**KIRKLEES METROPOLITAN COUNCIL
INVESTMENT & REGENERATION SERVICE**

Reference No: 2019/62/93637/W

Site Address: Holmfirth Civic Hall Community Trust, Huddersfield Road, Holmfirth, HD9 3AS

Description: Erection of roof over rear well to create enclosed space, erection of rear fire escape and interior and exterior alterations (within a Conservation Area)

Project	Proposed Refurbishments of Holmfirth Civic Hall		
Client	Holmfirth Civic Hall Community Trust		
Dwg Title	Views as Existing and Proposed		
Dwg No.	1825 - 03A	Date	31/12/2019

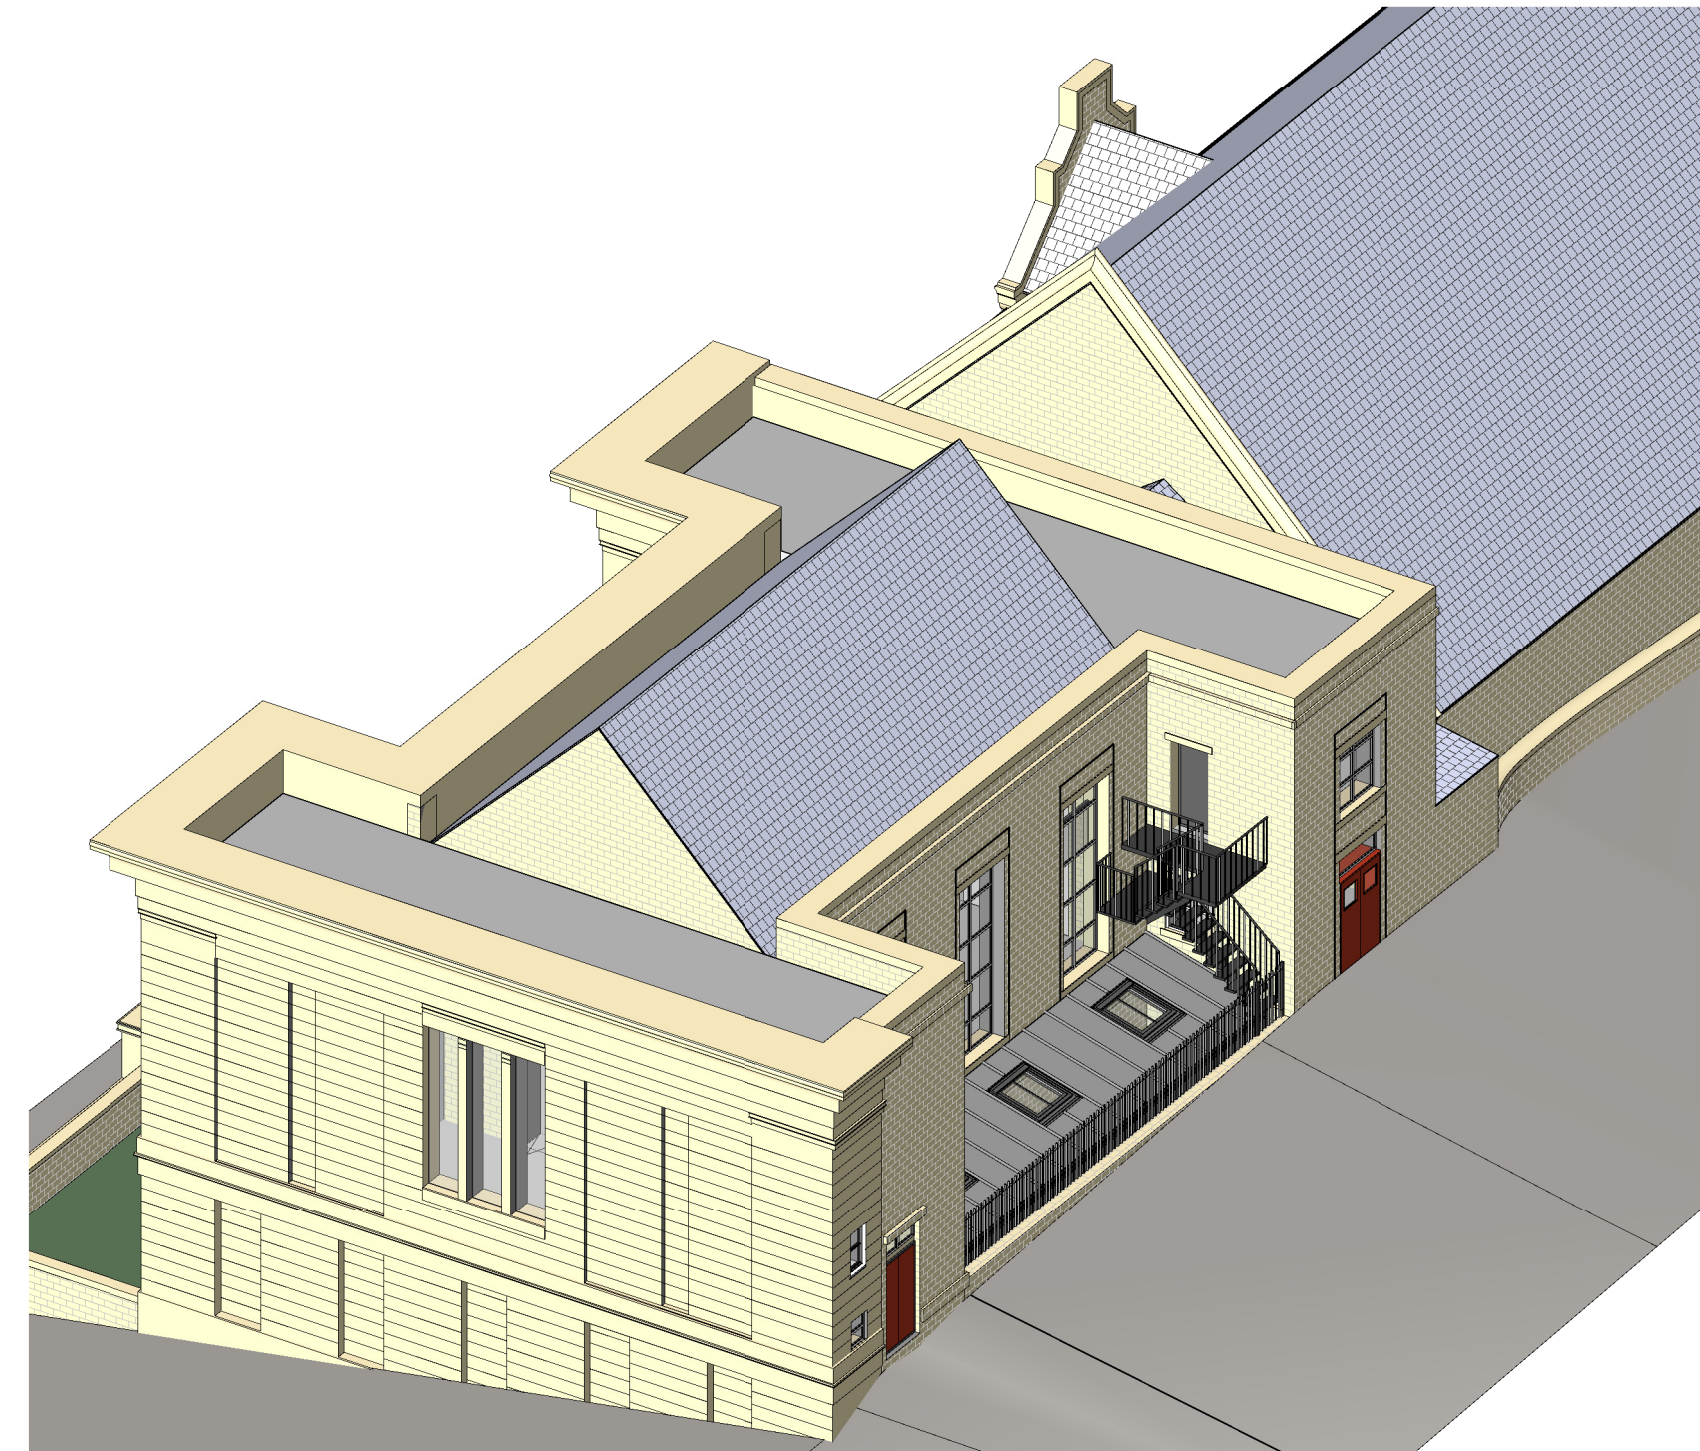
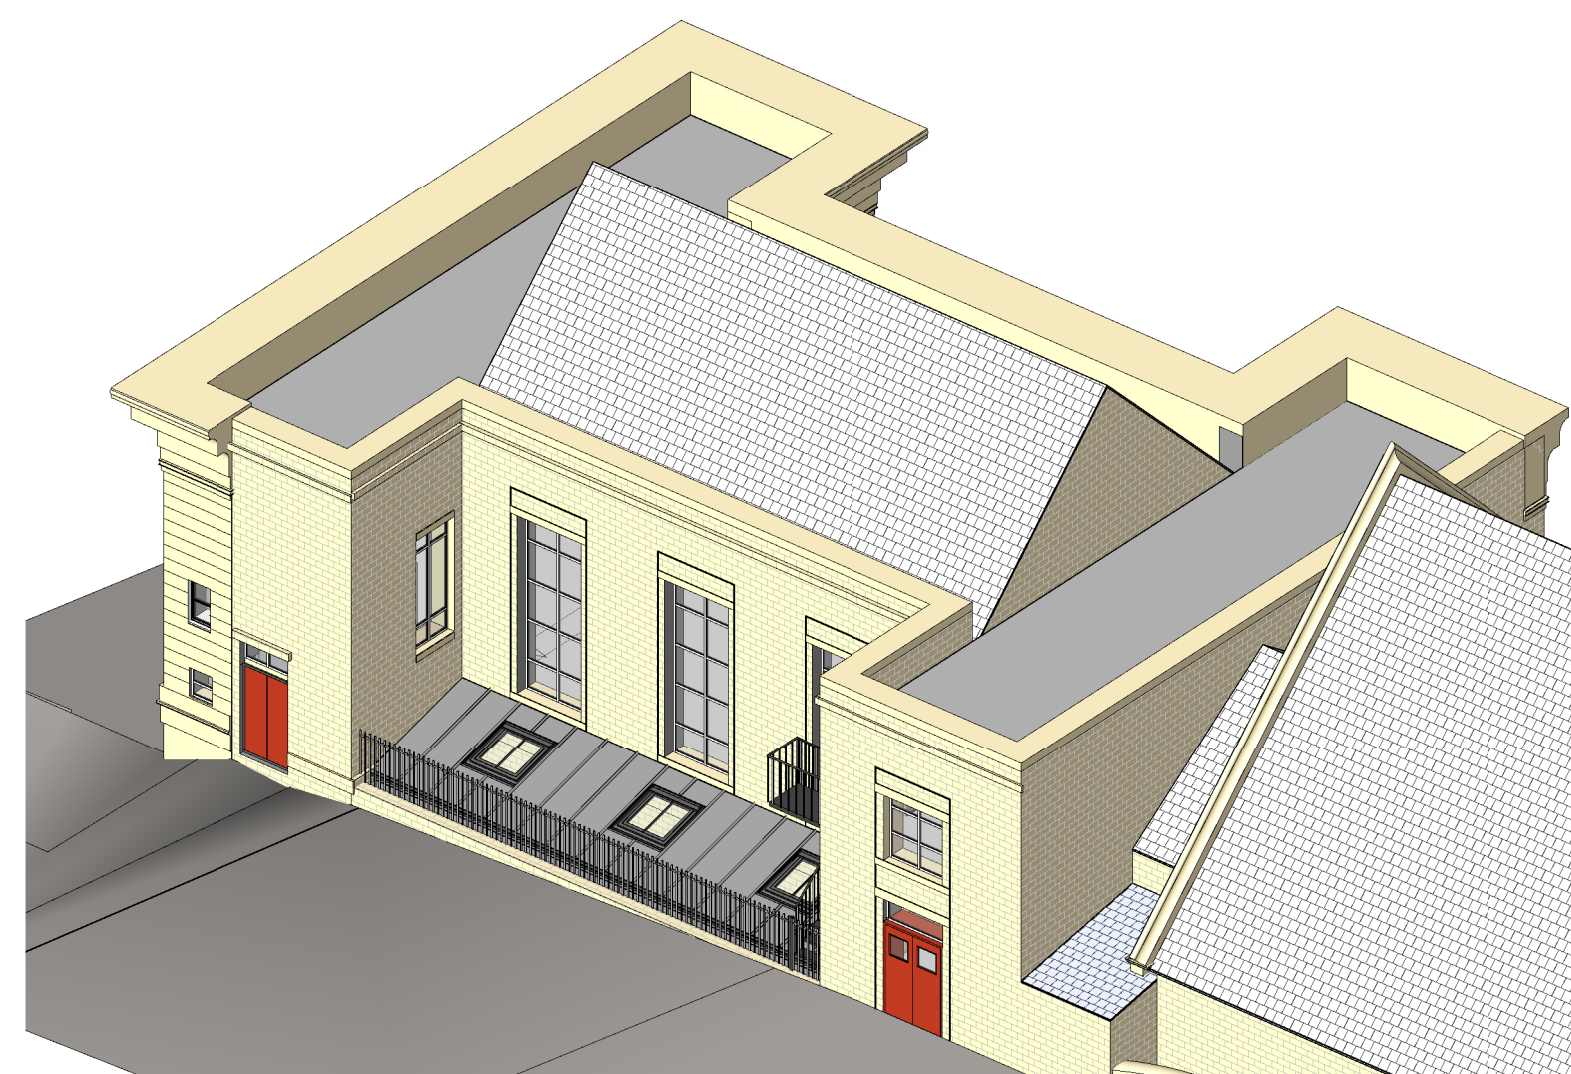
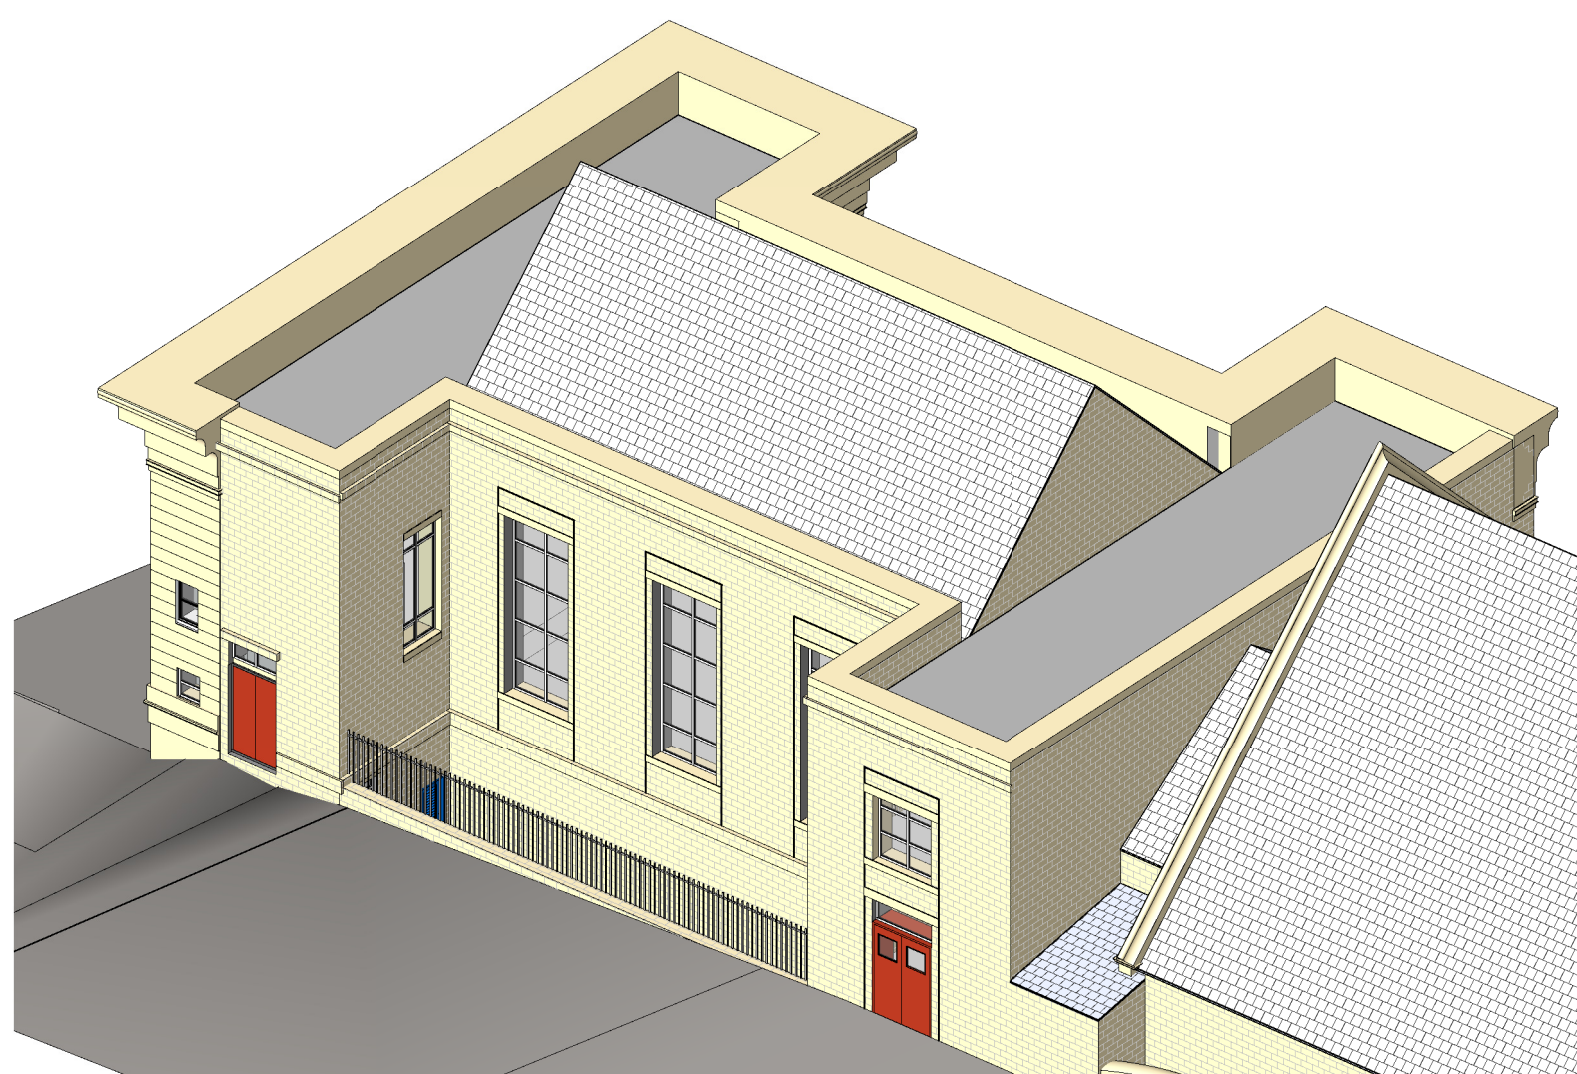
Negotiations between the officer and agent took place due concerns raised by Conservation and Design regarding the proposed first floor office window located behind the fire escape. Amendments were received accordingly on 01/01/2020.

Conservation and Design – concerns were raised in regards to the proposed first floor office window located behind the fire escape and instead a single window inserted adjacent to the existing rear exit door in this room is suggested or alternatively a vertical window on each side door.

character of the building. Further, the erection of a fire escape adjacent to the rear well facilitates an increase in capacity in the first floor meeting room. Whilst the works are fairly obtrusive the staircase is located on the rear of the building in an area of low significance. Whilst there are concerns regarding the siting of the structure in front of an existing window but this is as a consequence of the site constraints. The intervention of a large escape structure will lead to less than substantial harm to the character of the building and, on balance, it is considered that the public benefits in improving safety and enabling a sustainable use for the upper floor space outweighs the harm. Conservation and Design raised concerns about the proposed first floor office window located behind the fire escape and suggested that a single window is inserted adjacent to the existing rear exit door in this room or a vertical window on each side of the door. A revised drawing was submitted showing a modified window in the same position with a design that harmonises well with the overall rear appearance which on balance satisfies Conservation and Designs concerns.
